Please ask for: Nicola Moore
Email: nicola.moore@arun.gov.uk
Telephone: Ext 37944
Our Ref: LU/265/20/CLP
Your Ref:
Date: 13th October 2020

Lawful Development Certificate for a Proposed Use or Development

Development: Lawful Development for Proposed conversion to 1 No. ground level studio flat.
Location: Lower Floor Flat 17 St Catherines Road Littlehampton BN17 5HR

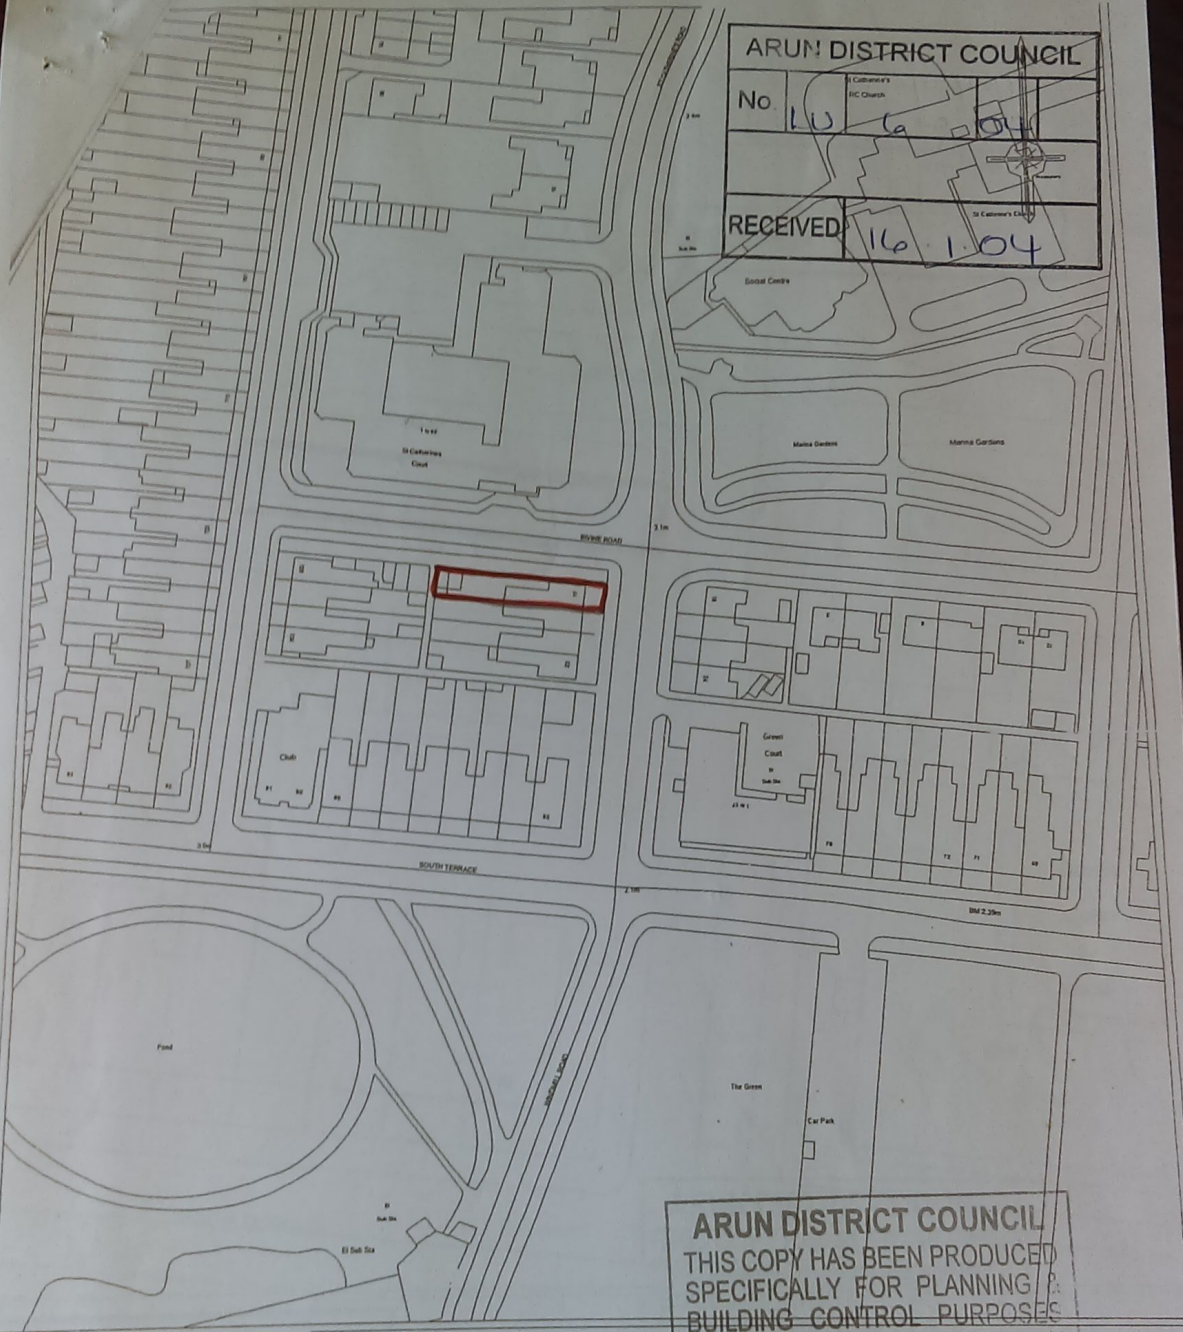
The submitted Location Plan is not to scale. Please re submit as a PDF file ensuring it is to the correct scale.

ELEVATIONS
EXISTING
AND
PROPOSED
-
NO CHANGE

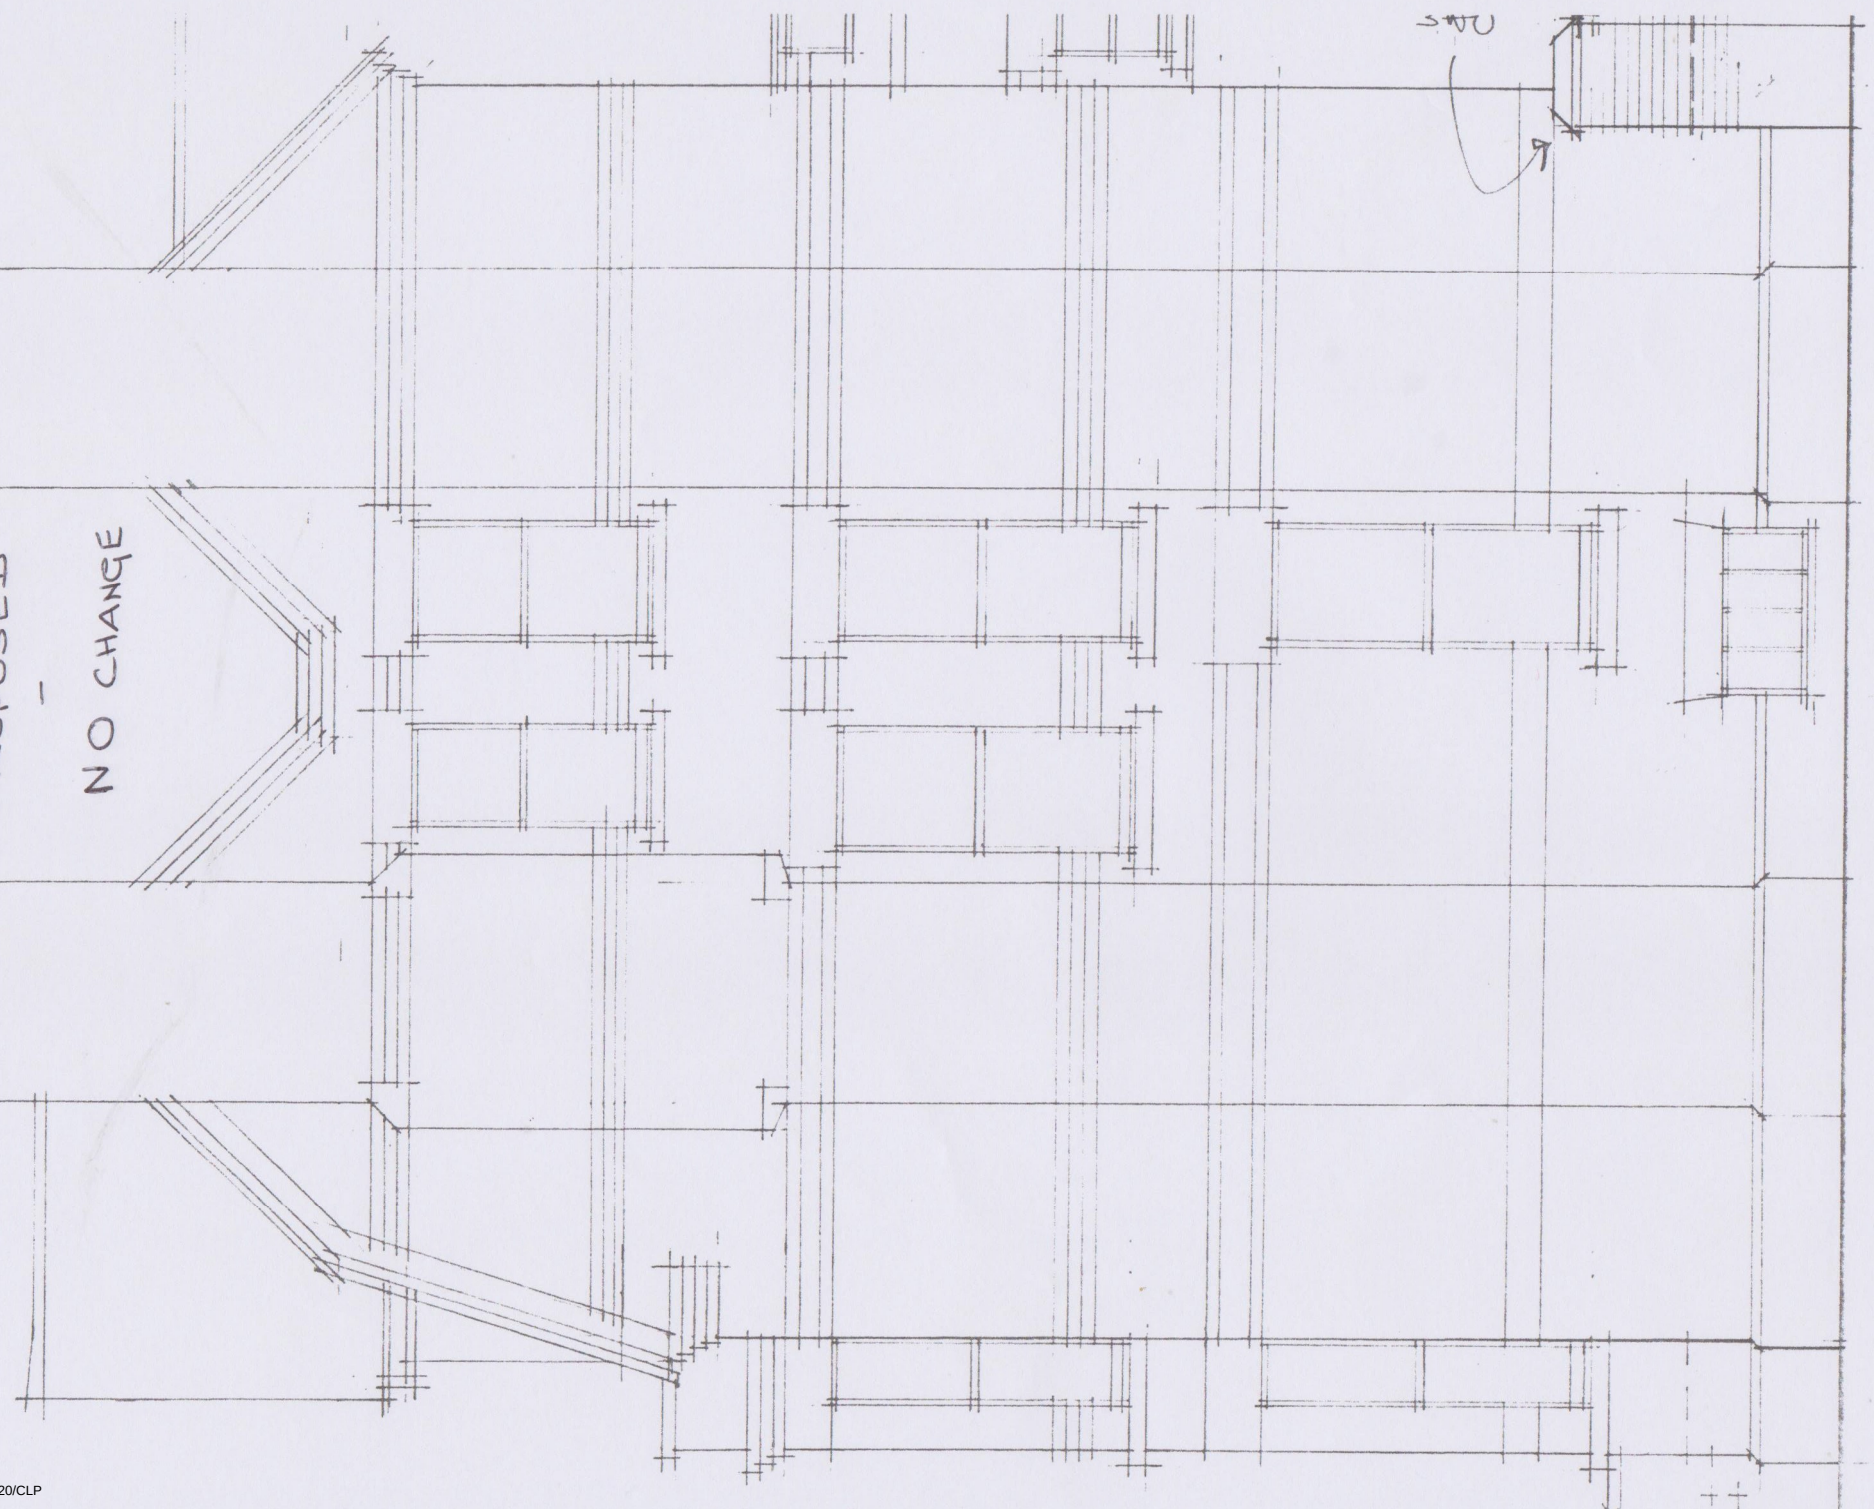
The Elevations do not appear to show the windows on the side elevation. Please amend and re submit.

The submitted Elevations are not to scale. Please re submit ensuring they are the correct scale. Alternatively, the scale bar can be removed and all window and door dimensions can be written on the plan (in metric).

Block Plan shows area bounded by: 502898.41, 101623.01 502934.41, 101659.01 (at a scale of 1:200), OSGridRef: TQ 291 164. The representation of a road, track or path is no evidence of a right of way. The representation of features as lines is no evidence of a property boundary.

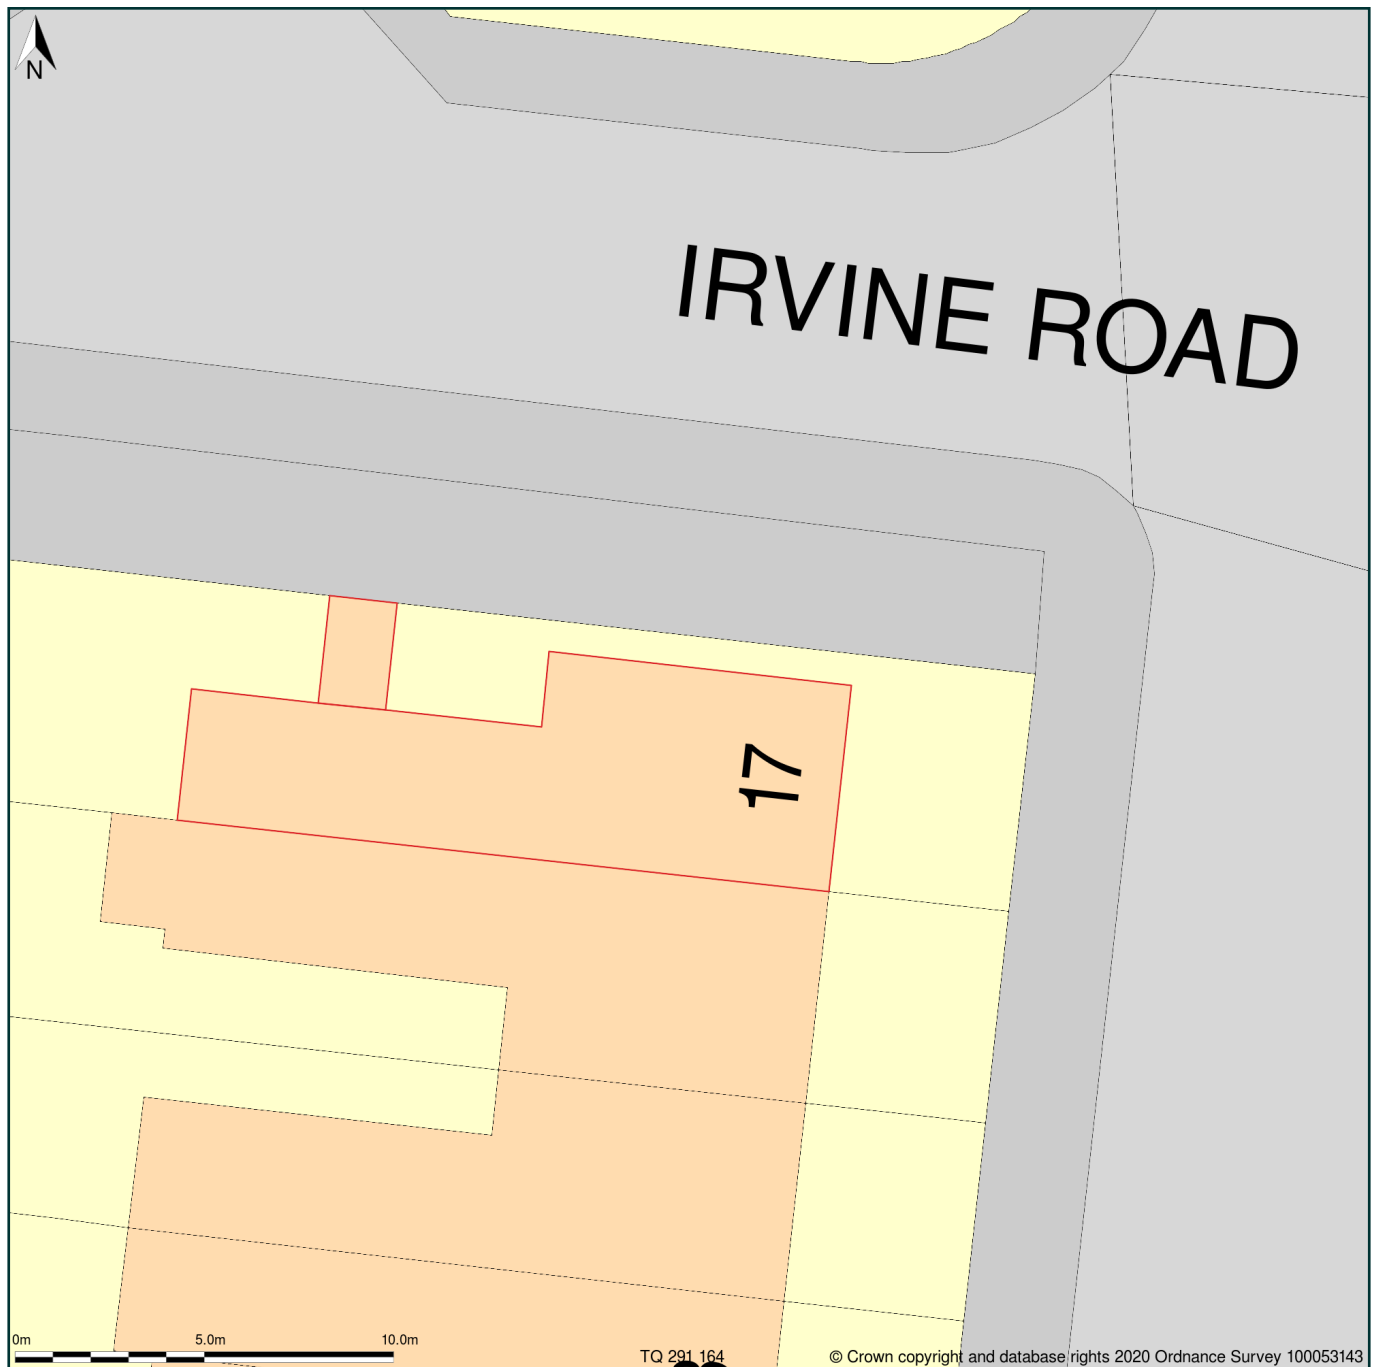
The submitted Block Plan is not to scale. Please re submit as a PDF ensuring it is to the correct scale

EXISTING FLOOR PLAN

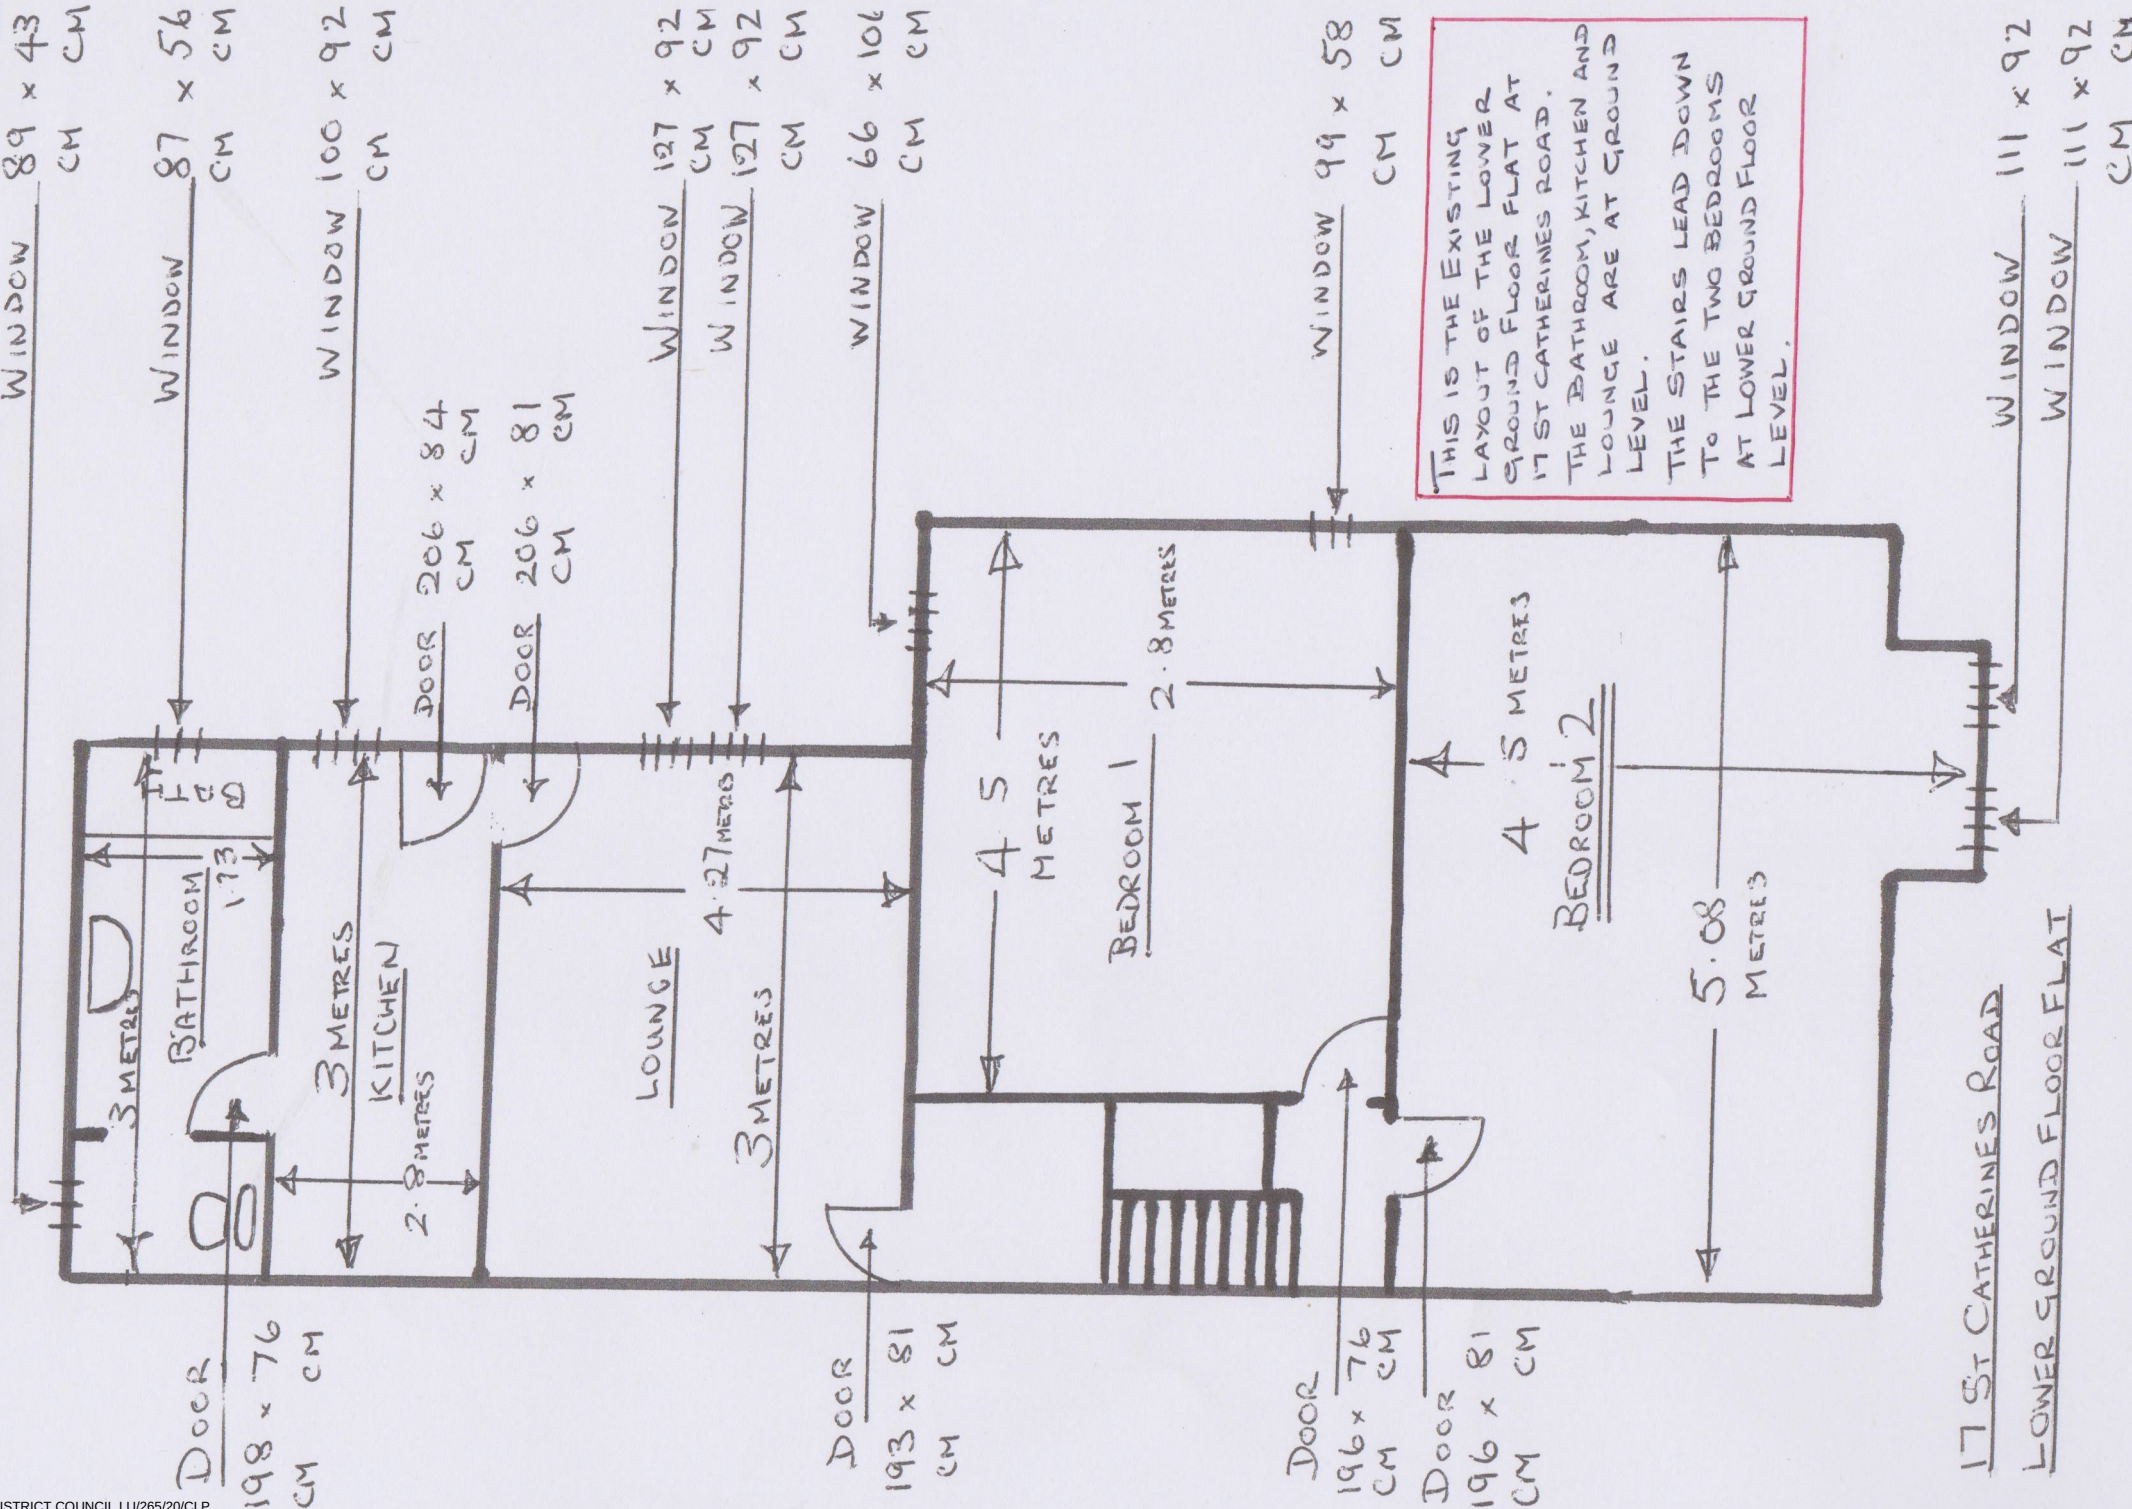
The floor plans appear to show the proposed studio flat on a different floor level (ground floor). Please submit clearly labelled existing and proposed lower ground floor and ground floor plans.

The submitted Floor plans are not to scale. Please re submit ensuring they are to scale, alternatively, the scale bar can be removed and all window and door dimensions can be written (in metric).

The Proposed Floor Plan does not include the bedroom area in the layout. Please amend accordingly.
